CHANGE SCHEDULE

REV B - 17.06.26

ELEVATION NORTH

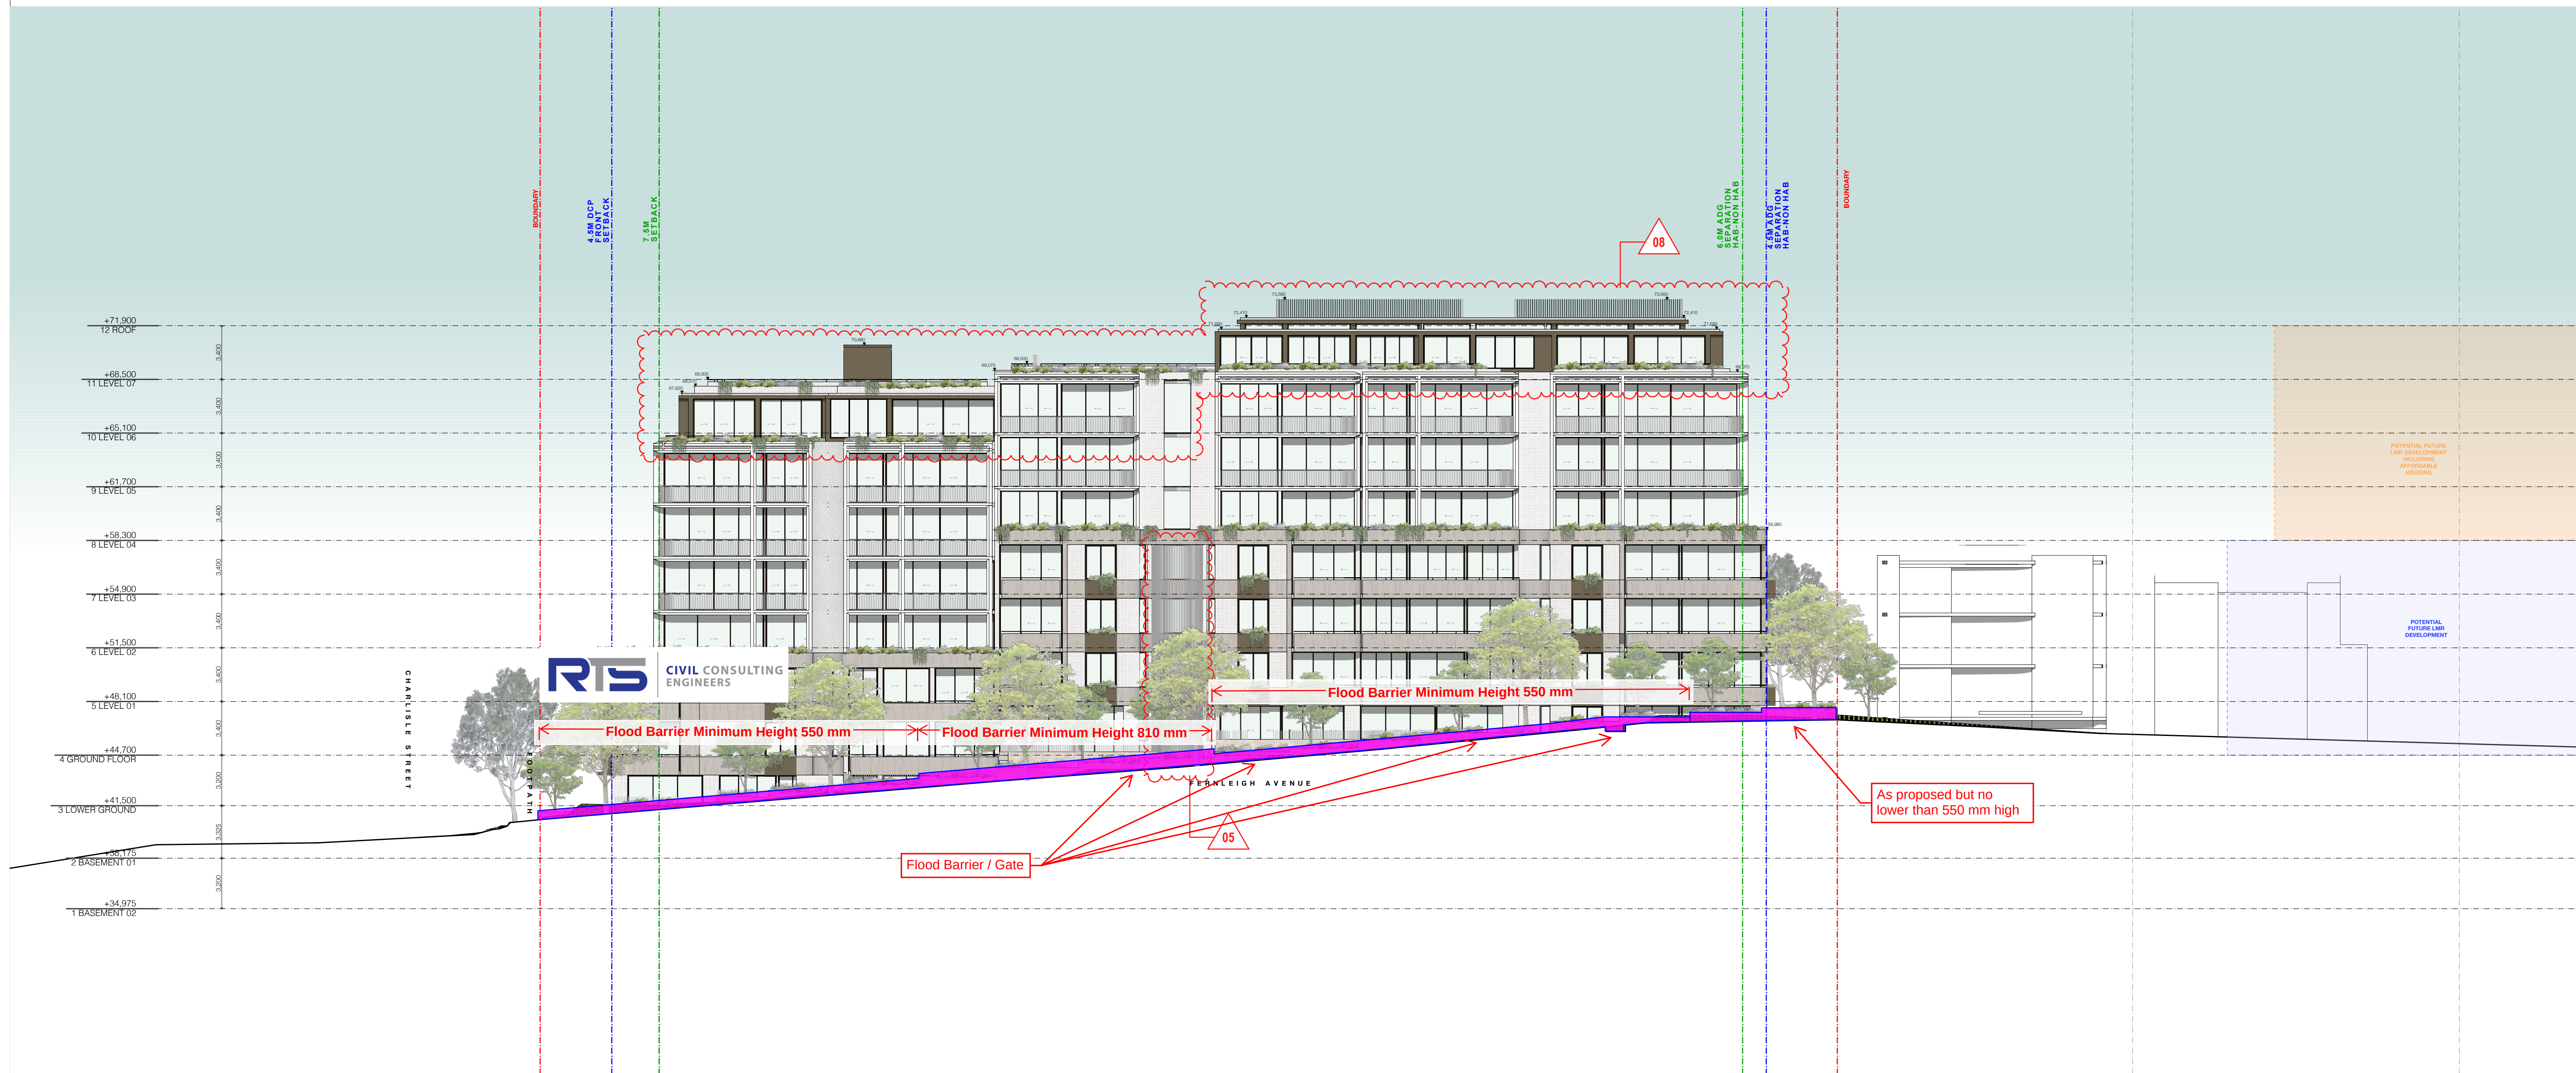
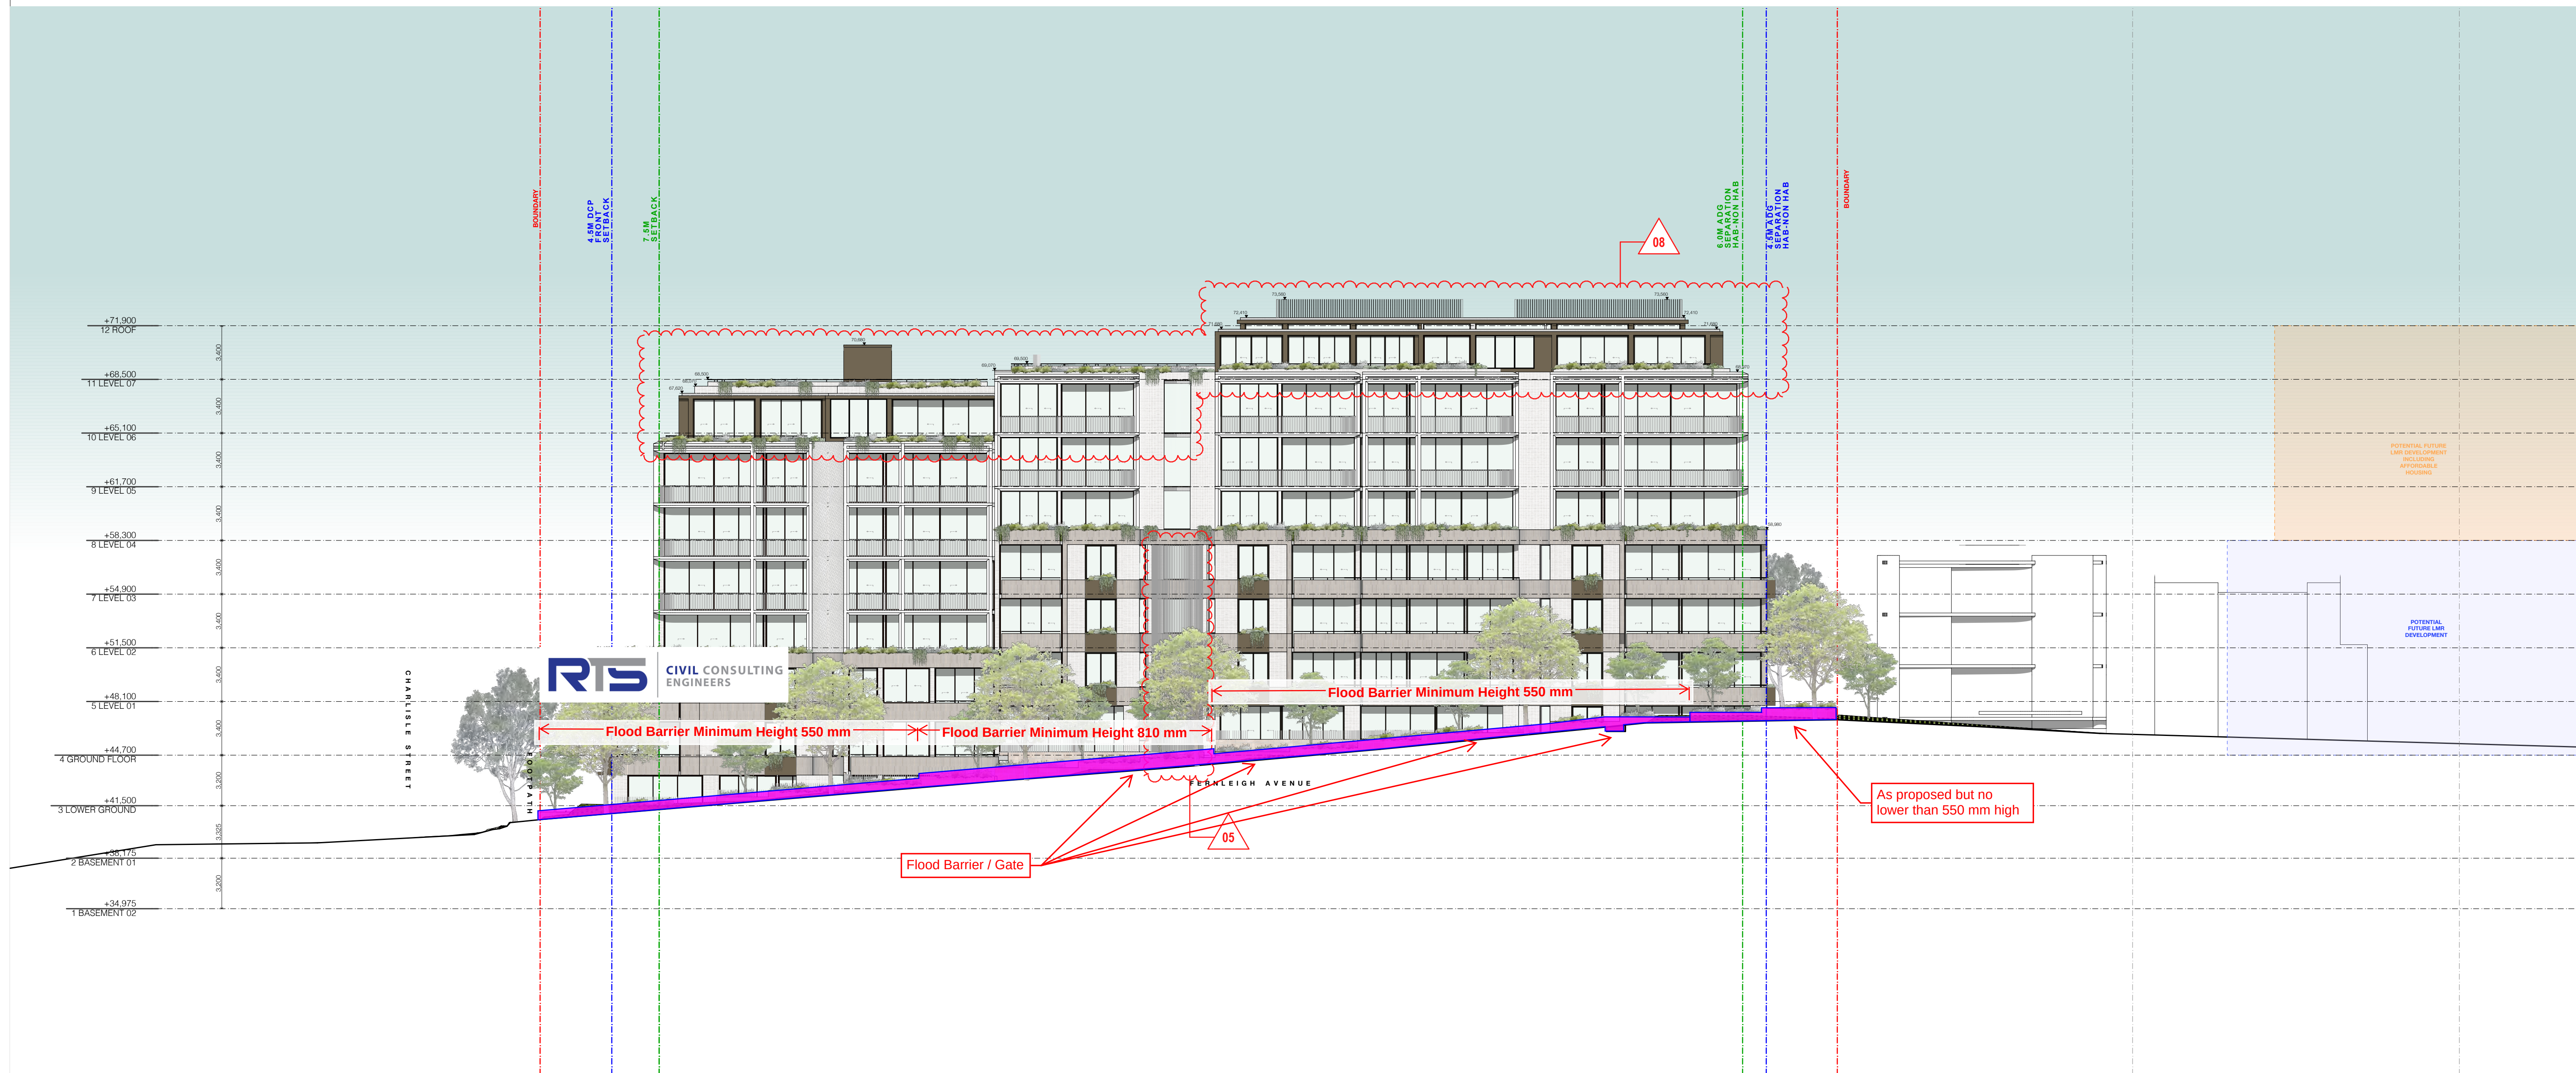
Refer to flood impact report.	
BUILDING HEIGHT		
DPHI ITEM 8		
Identify the overall RL of the proposal, including the screening to the plant enclosure on the roof.	RL's added to all sections + elevations including screening, parapet and lift overrun heights	3000 - North Elevation - Rev B 3001 - East Elevation - Rev B 3002 - South Elevation - Rev B 3003 - West Elevation - Rev B 4000 - Section AA - Rev B 4001 - Section BB - Rev B
DPHI ITEM 9		
The existing ground level depicted on the architectural drawings fails to accurately represent the existing ground levels shown on the site survey, including existing inground pools and basements along Fernleigh Avenue. Accordingly, the architectural drawings fail to accurately identify the maximum permissible building height line (i.e., 29.6 m above the existing ground level). Provide updated elevation, section and, if required, axonometric plans that identify the maximum permissible building height line. Any breaches to the maximum permissible building height development standard under Clause 16(2) of the Housing SEPP are to be clearly demonstrated and supported by a Clause 4.6 written justification.	Secondary height plane diagram has been provided which demonstrates the 'existing' ground condition including existing pool, garages and driveways.	4000 - Section AA - Rev B 4001 - Section BB - Rev B 4002 - Section CC - Rev B 6004.1 - Existing Ground Level Condition - Rev B 6005.1 - Height Plane Diagrams - Sheet 01 6005.2 - Height Plane Diagrams - Sheet 02
